From: Simon Davis <Simon.Davis@arun.gov.uk>
Sent: 09 December 2020 16:28
To: Planning.Responses <Planning.Responses@arun.gov.uk>
Subject: FW: AW/319/20/DOC- The Former Ship Inn Aldwick Street

Further Drainage Engineer Consultation Advice

Block Plan
scale 1:500 @ A1

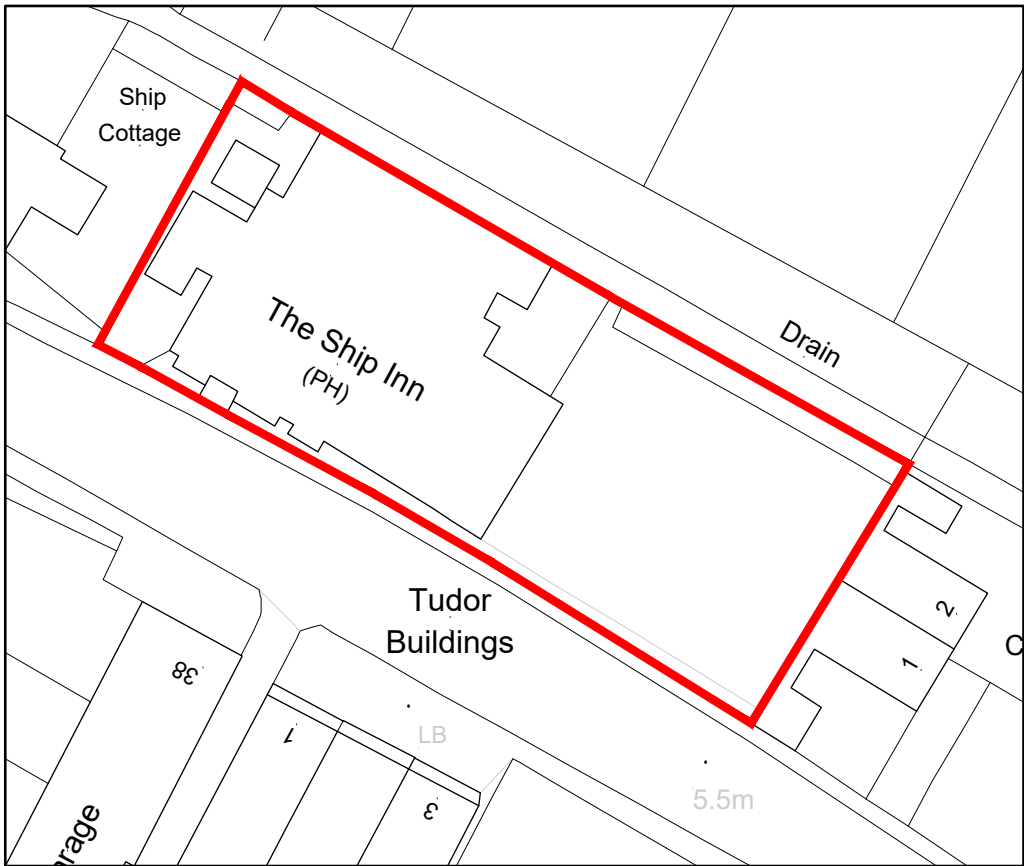
The proposals set out in the extracted text in your email of the 30th November should be okay. Can we get a plan to show this.

Whilst I was on site I noted that they are constructing an unconsented outfall to the watercourse, the condition of the wall is poor and requires investigation and that the ditch requires clearance. These are points that Paul and I will be pursuing further. I also advised that we wish to make an inspection of the watercourse prior to the fence being constructed to ensure that it has been cleared.

Exploded view of post and clip for Multiplus panel system

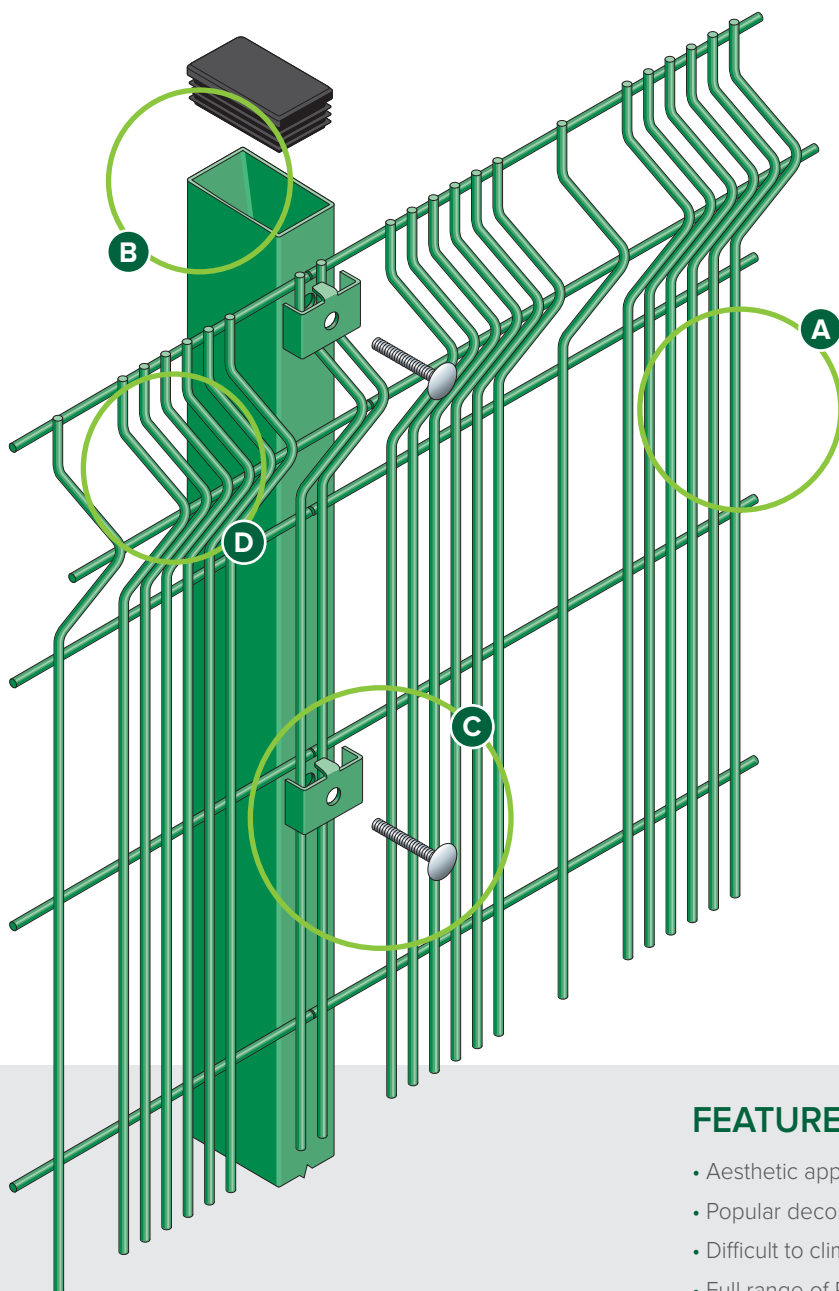
With regard to the request for a demountable fence being provided, you will note from the already submitted details, that the fence is of a bolted site assembly type. In can therefore be easily dismantled. To further aid accessibility, we shall provide the post nearest the gate leading edge/lock, to have a bolted cleat fixing, rather than being cast into concrete. With the post and single adjacent panel removed, and the gate in an open position, then access will be available for all of the below activities to the watercourse.
